**COLORADO SPRINGS FIRE PREVENTION
PLAN REVIEW REPORT**

Project Description: Father and Sons Whiskey Purveyors, 1405 Selix Grv, New Distillery, Office, Assembly and Barrel Storage Warehouse

Plan Id: 20190806-DV-1

Review Status: DISAPPROVED

6 FIRE LANE SIGN
SCALE: 1 1/2"=1'-0"

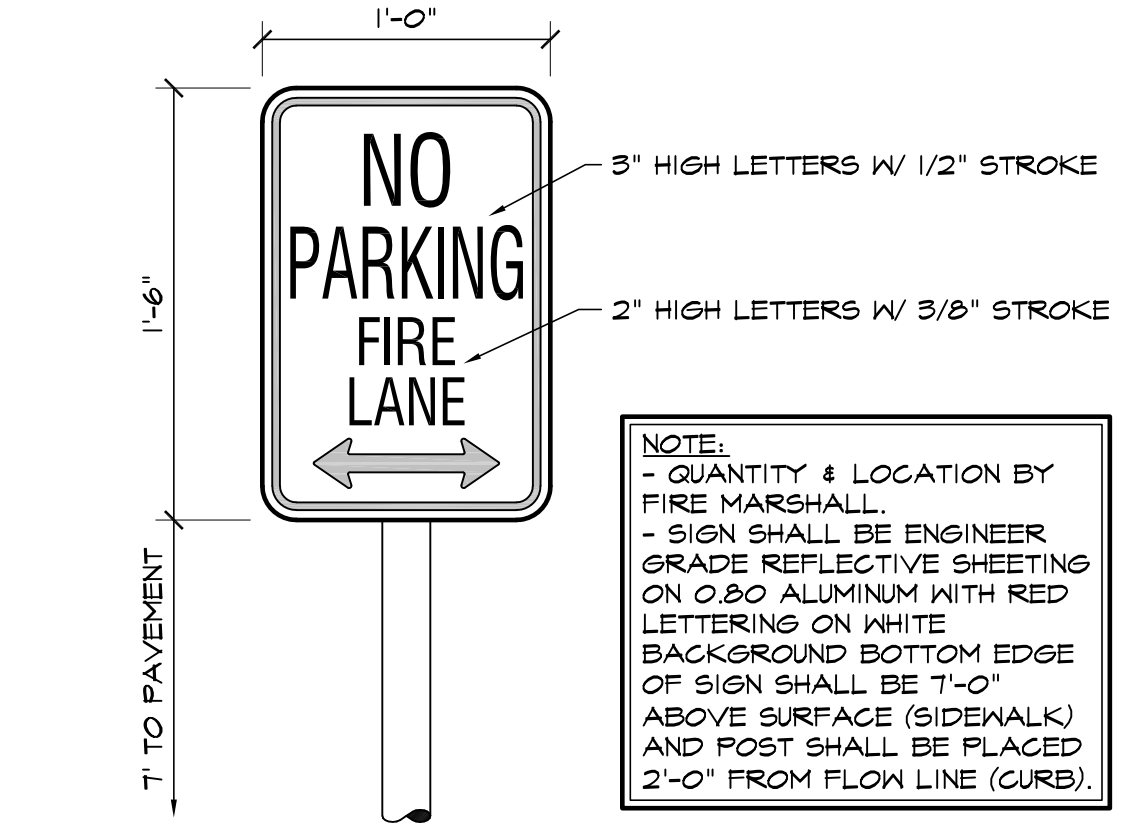
Found fire lane signage detail on plans, but unable to locate fire lane locations. Show these locations on the plans. Note that apparatus will not need to drive completely around the building to meet fire code requirements.

1 SITE PLAN
SCALE: 1"=20'-0"

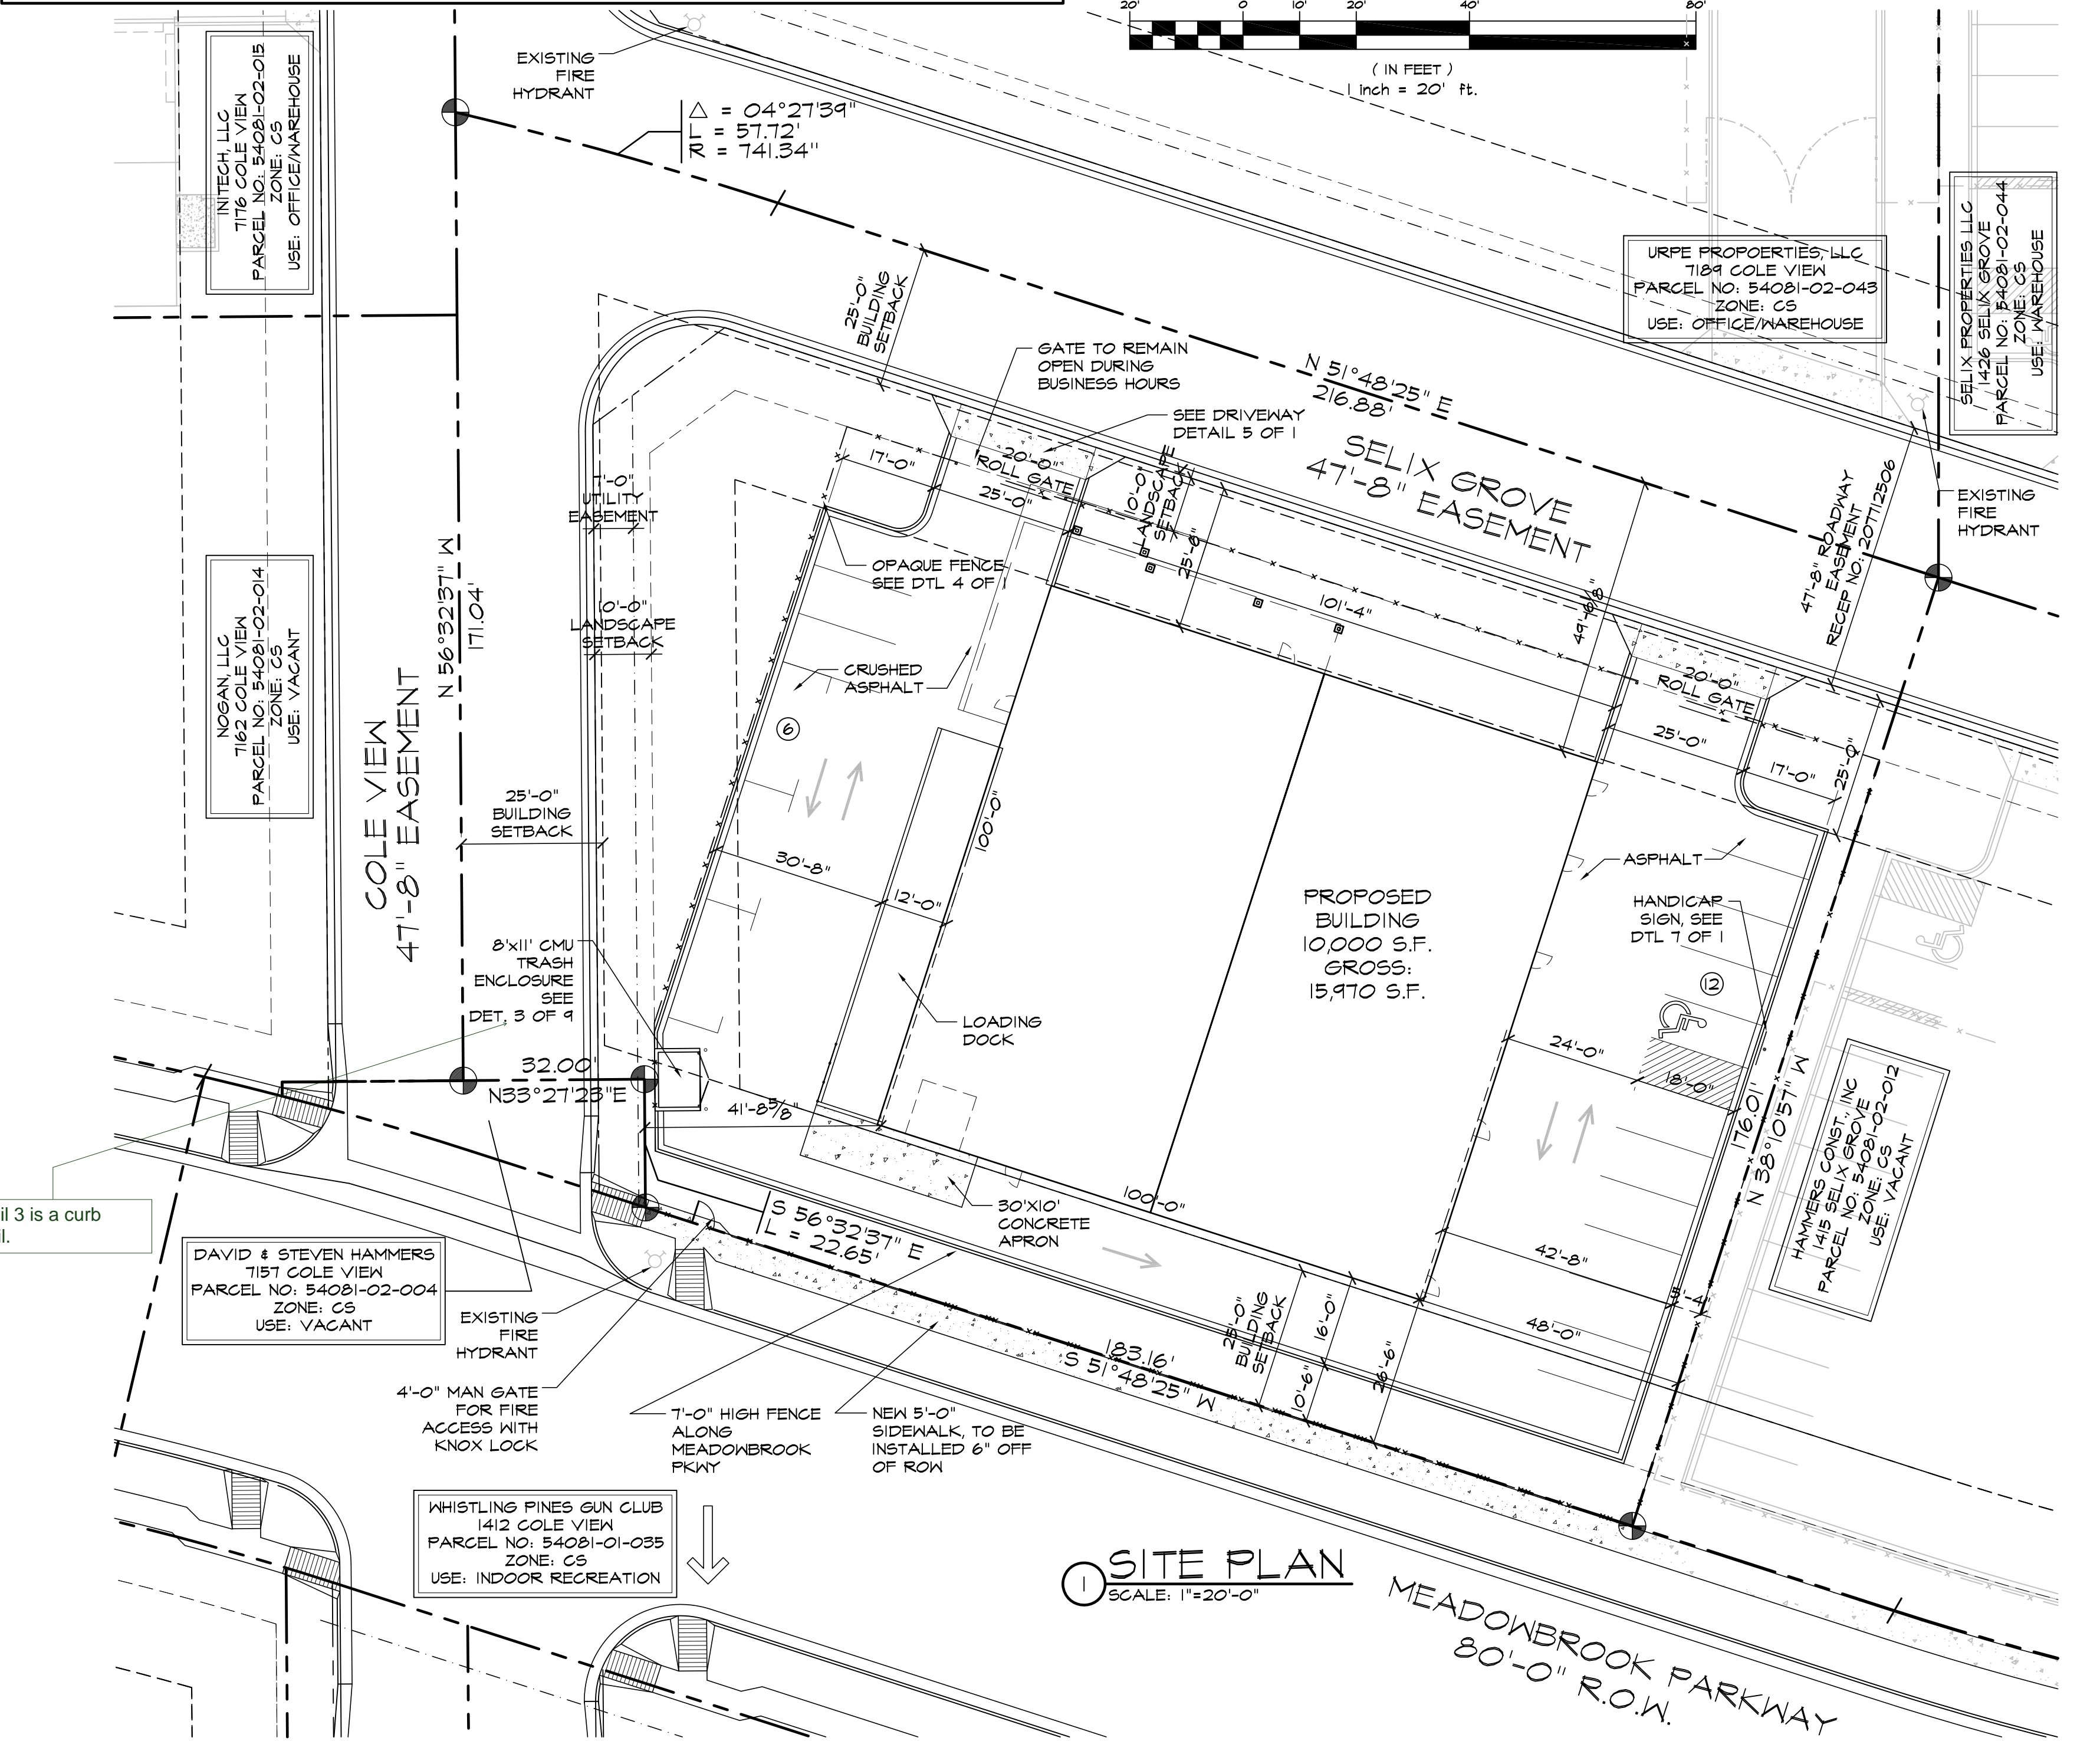
Show where parking is allowed along Selix Grove to ensure fire apparatus have adequate clearance to turn into each driveway. If necessary, indicate any no parking zones to accommodate fire apparatus turning onto the site.

Plans indicate the building will be fire sprinklered. However no FDC and/or fire hydrants are shown on the plans. Show the FDC and any/all required fire hydrants for the building.
